**Consultation Response from Alan Smith,
KC Waste Strategy (Refuse & Recycling)**

2025/93087 Wappy Springs Inn, Lindley Moor Road, Lindley Moor, Huddersfield, HD3 3TD

Date Responded: 18/11/2025

Responding Ref: WPS 25 056

Drawing Title  
**TYPICAL BIN STORE DETAILS**

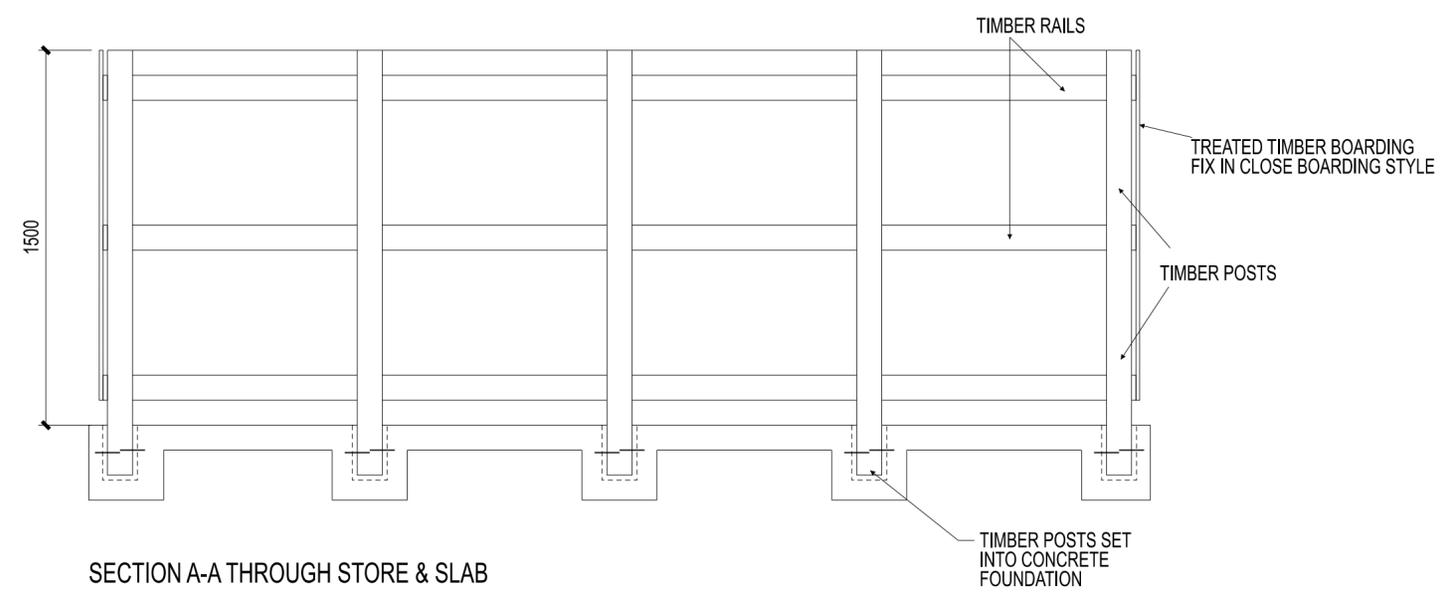
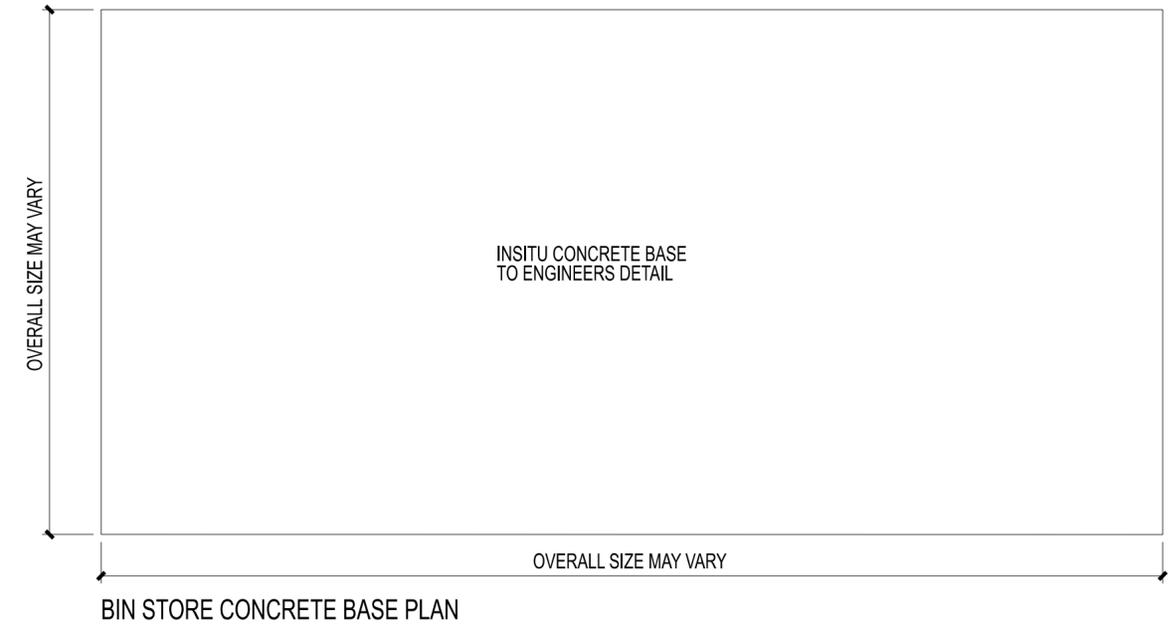
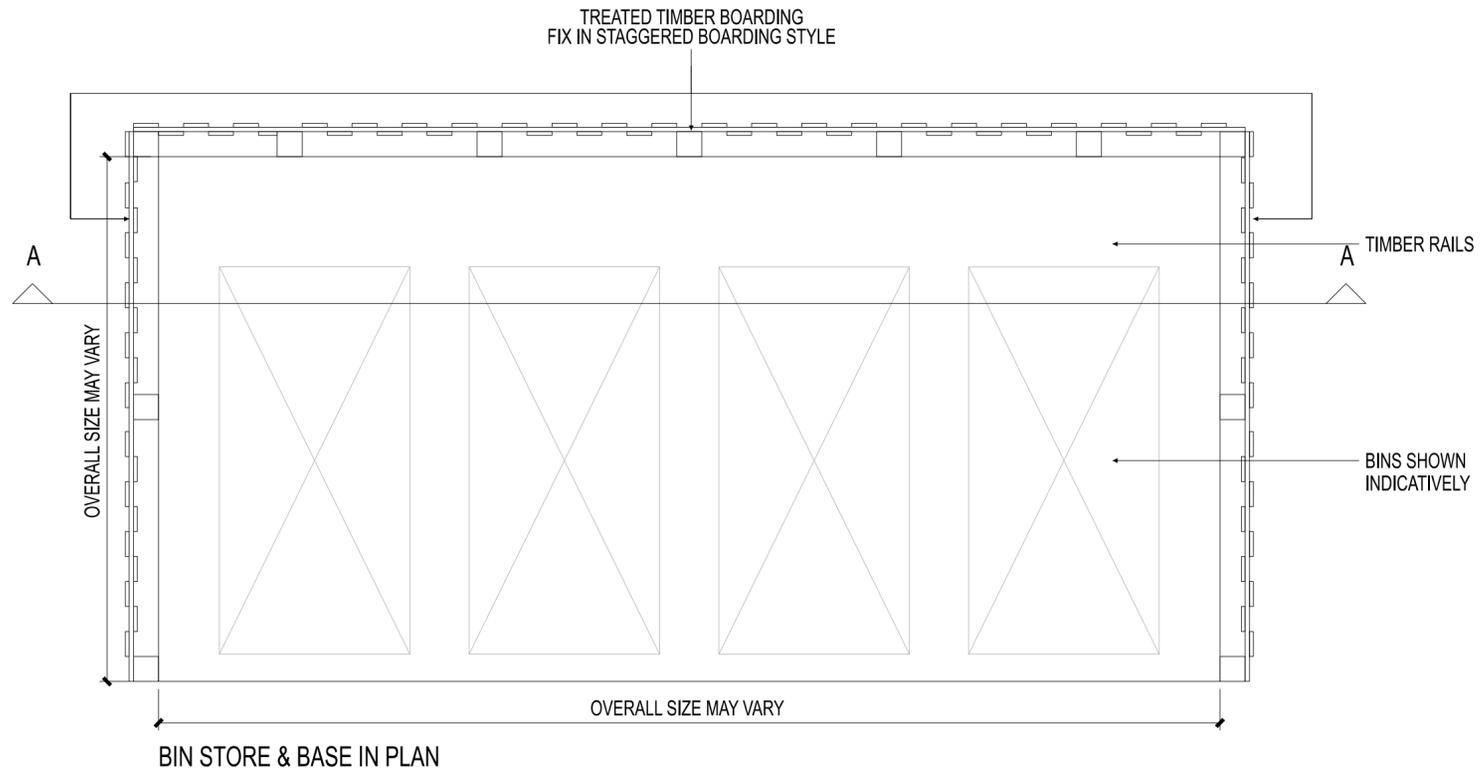
Although the drawing shows the robust construction of the bin store, it needs to be secure to ensure it is vandal proof and secure to prevent fly-tipping, unauthorised use and spreading of waste into the surrounding area. The diagram shows the bin store open at the front with the bins placed side on not facing the front. This configuration makes it difficult for users to know what waste to put in each bin.

The WCA would like to see how the bins will be secured, how they will be configured and the material that will be collected. Also, the size of the bin store needs to be confirmed.

Given the information provided by the developer the WCA **cannot** agree to the Discharge of Condition 13 for the site.
